## PAVEMENT DESIGN REPORT

**Skyline at Lorson Ranch, Filing No. 1  
El Paso County, Colorado**

**September 8, 2022  
Revised September 27, 2022**

**APPROVED  
Engineering Review**

TYPICAL SECTIONS

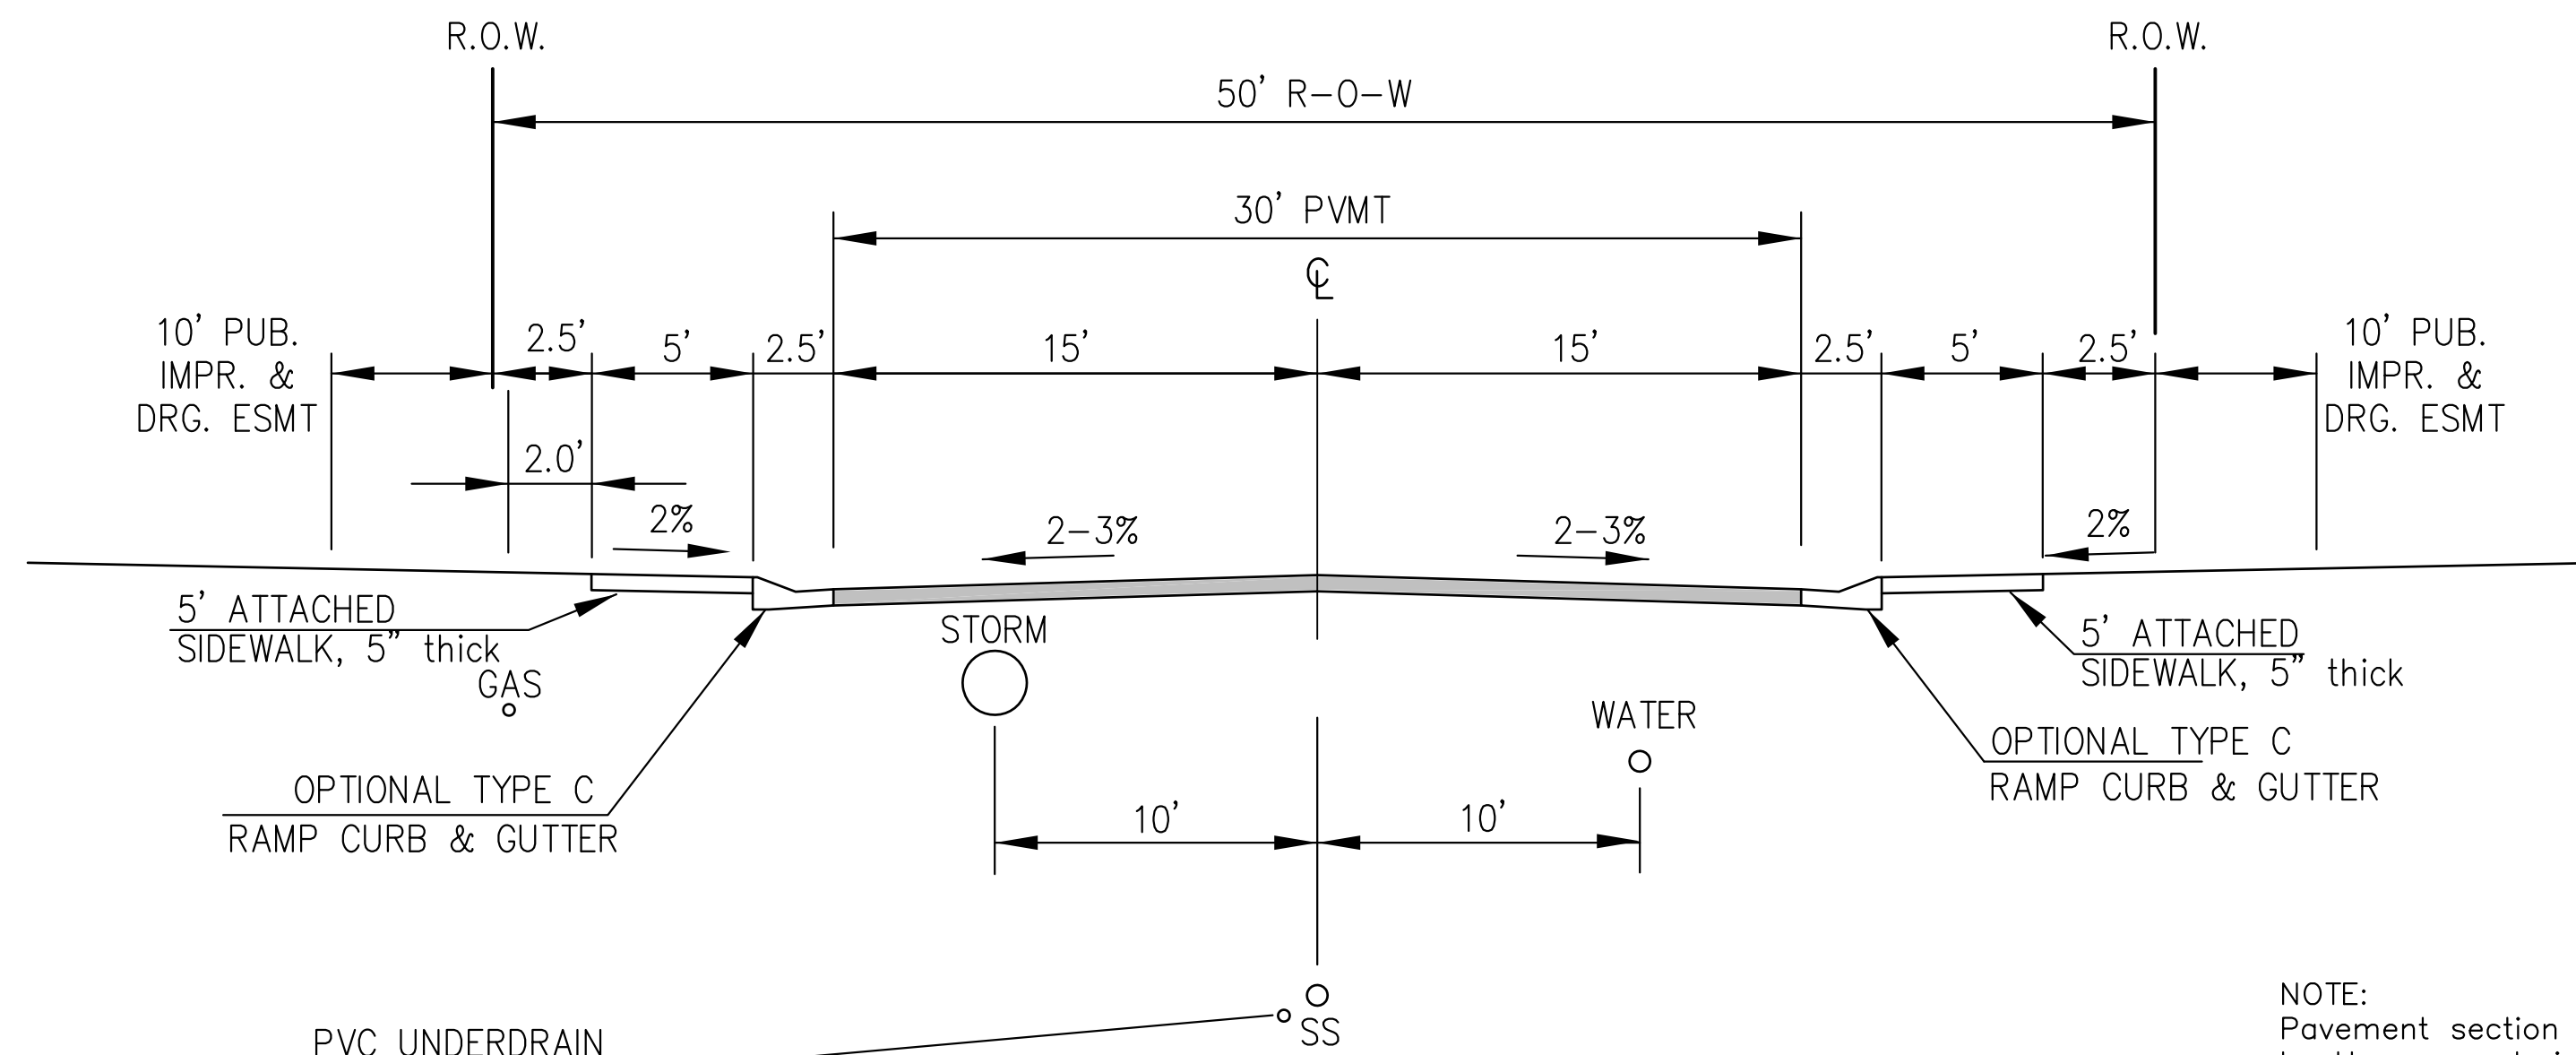
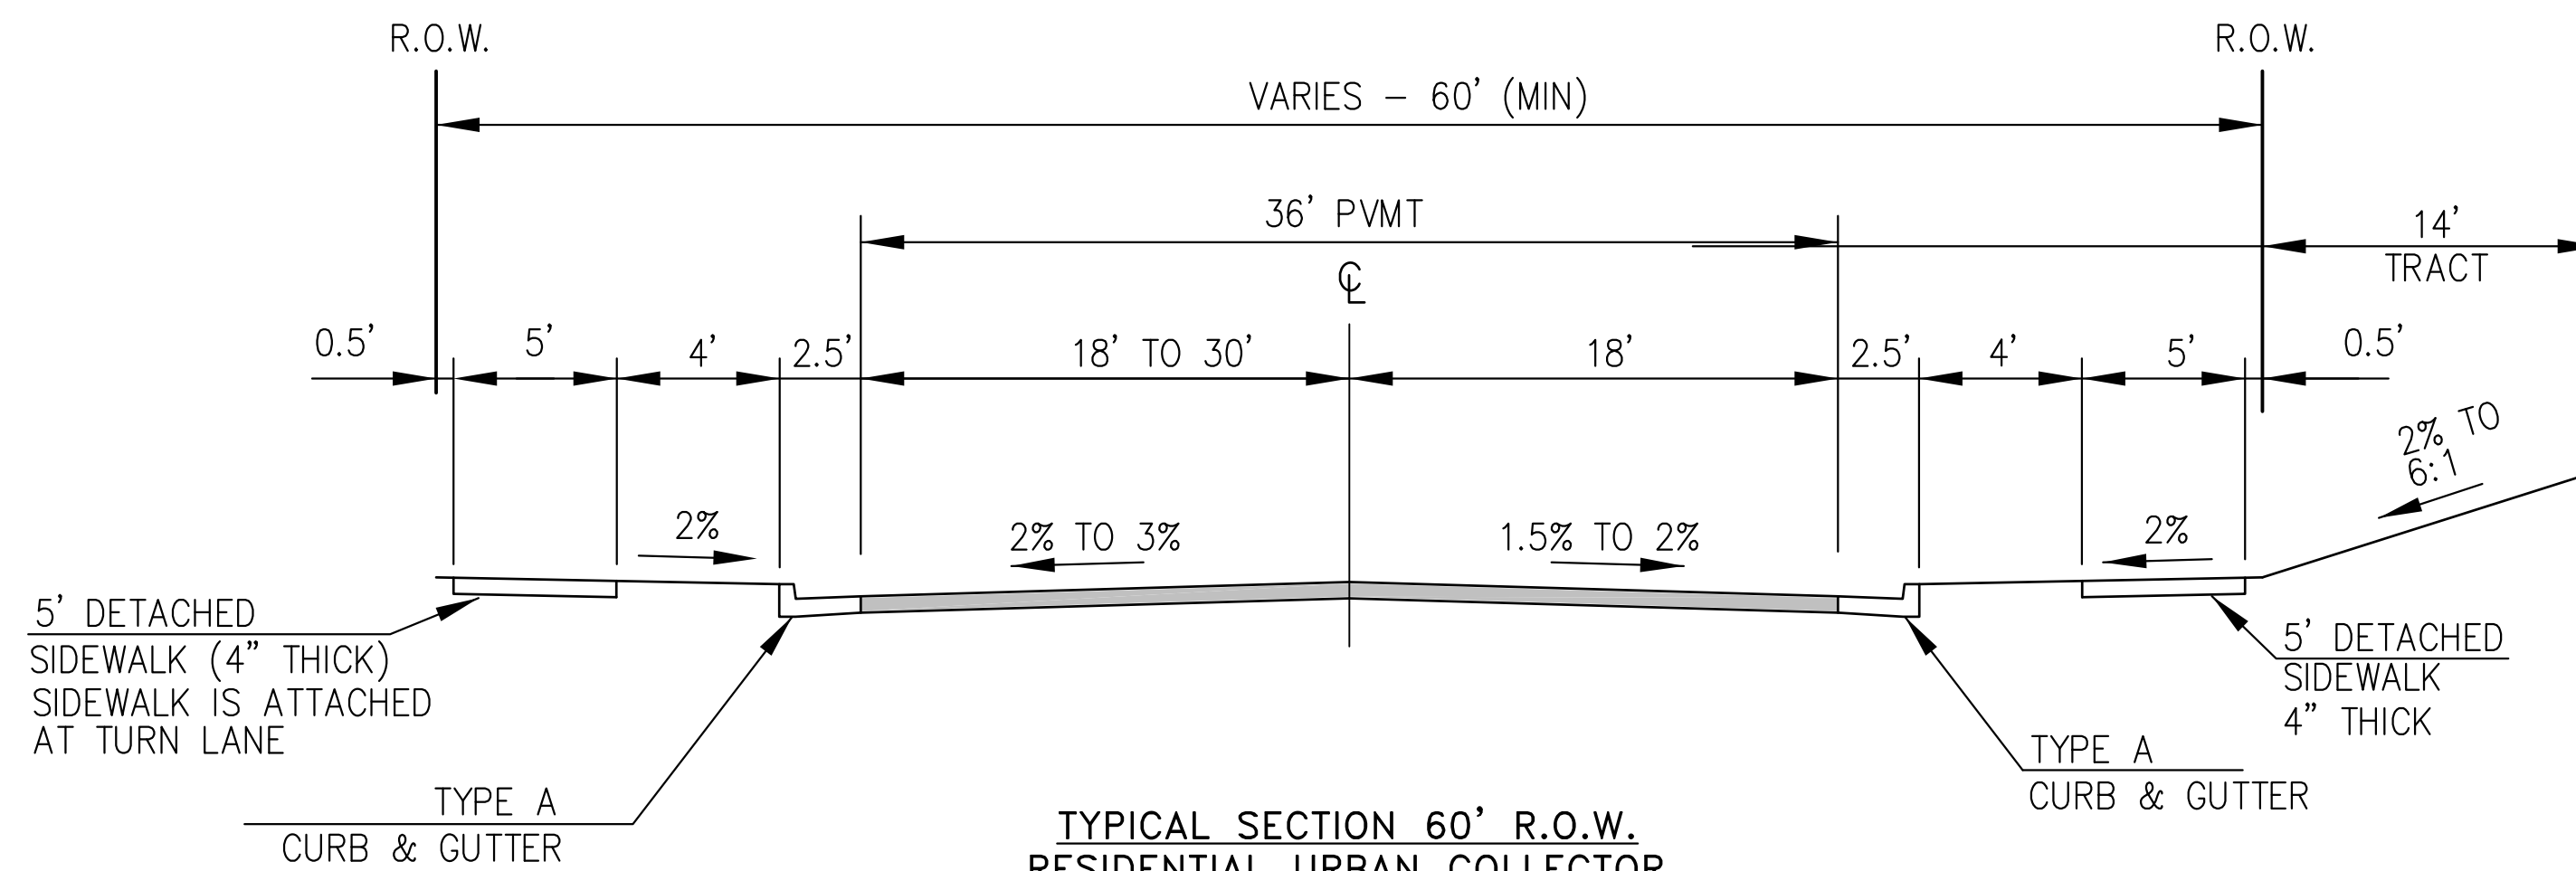
EPC Planning & Community  
Development Department  
Condition: For the Local  
Residential roads, only  
Option 1 may be used.
